KIRKLEES METROPOLITAN COUNCIL INVESTMENT & REGENERATION SERVICE

DELEGATED DECISION TO DETERMINE APPLICATIONS FOR LISTED BUILDING CONSENT

Reference No:	2025/44/91273/W
Site Address:	Edgerton Cottage, 15, Edgerton Road, Edgerton, Huddersfield, HD3 3AA
Description:	Discharge of details reserved by condition 3 (joinery details of window 15) on previous permission 2024/93011 for variation condition 2 (plans) on previous consent (ref: 2024/91037) for Listed Building Consent for replacement windows and doors (within a Conservation Area) to add additional window details
Recommending Officer:	Sheena Campbell

2025/91273 - Officer Report

1 X Sliding Sash - SS39

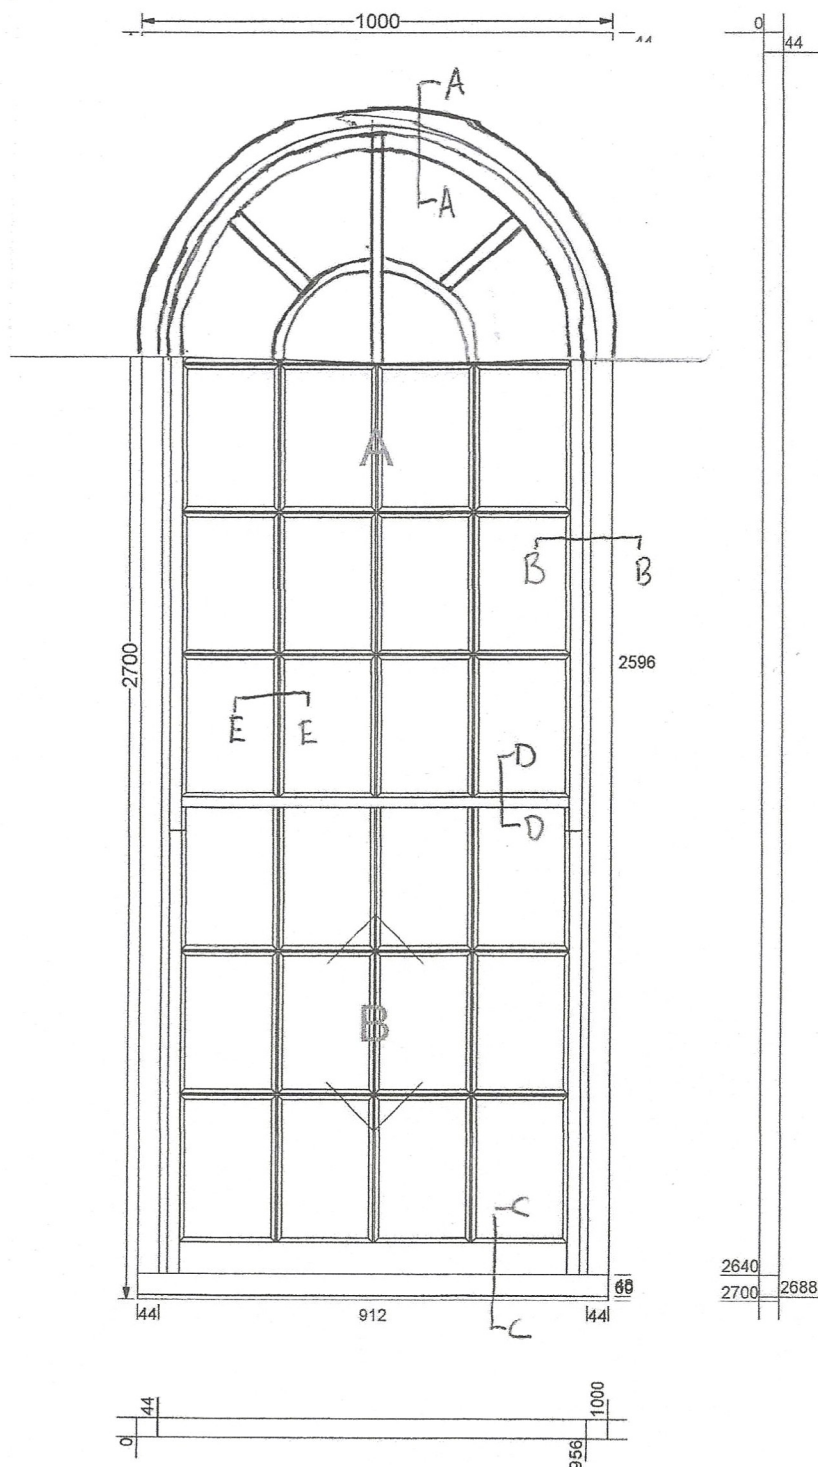
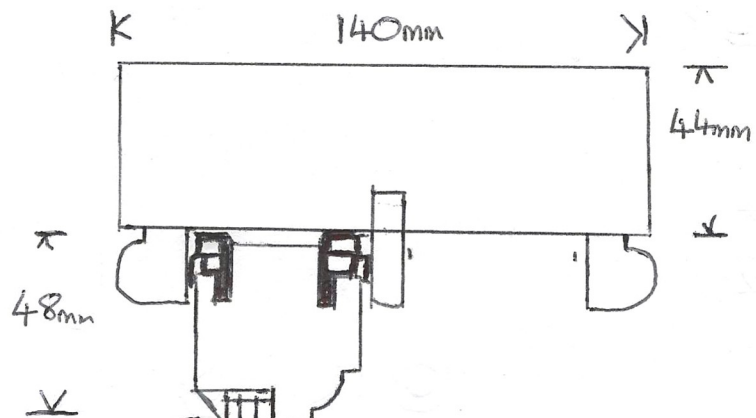
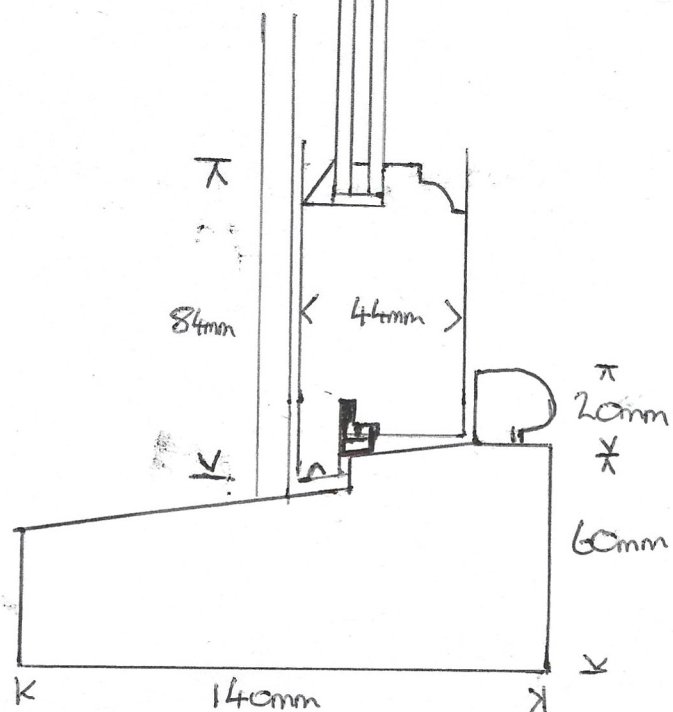
With regards to discharging Condition 3 details have been submitted on Window details, sections and profiles. The condition was imposed to ensure that the detailing of the large arched window does not harm the character and significance of the listed building. The information provided is detailed enough to discharge condition 3 as the details show that the proposed arched window will have slimlite double glazed units with sections at 4mmx4mmx4mm and glazing bars at 22mm and meeting rail at 30mm to the correct design and detailing.

The information provided is detailed enough to discharge condition 3 as it demonstrates the details and sections of the slimlite double glazing.

This is acceptable for the purposes of condition 3 of permission 2024/93011. The approved window details shall, from the completion of the works, be retained thereafter.
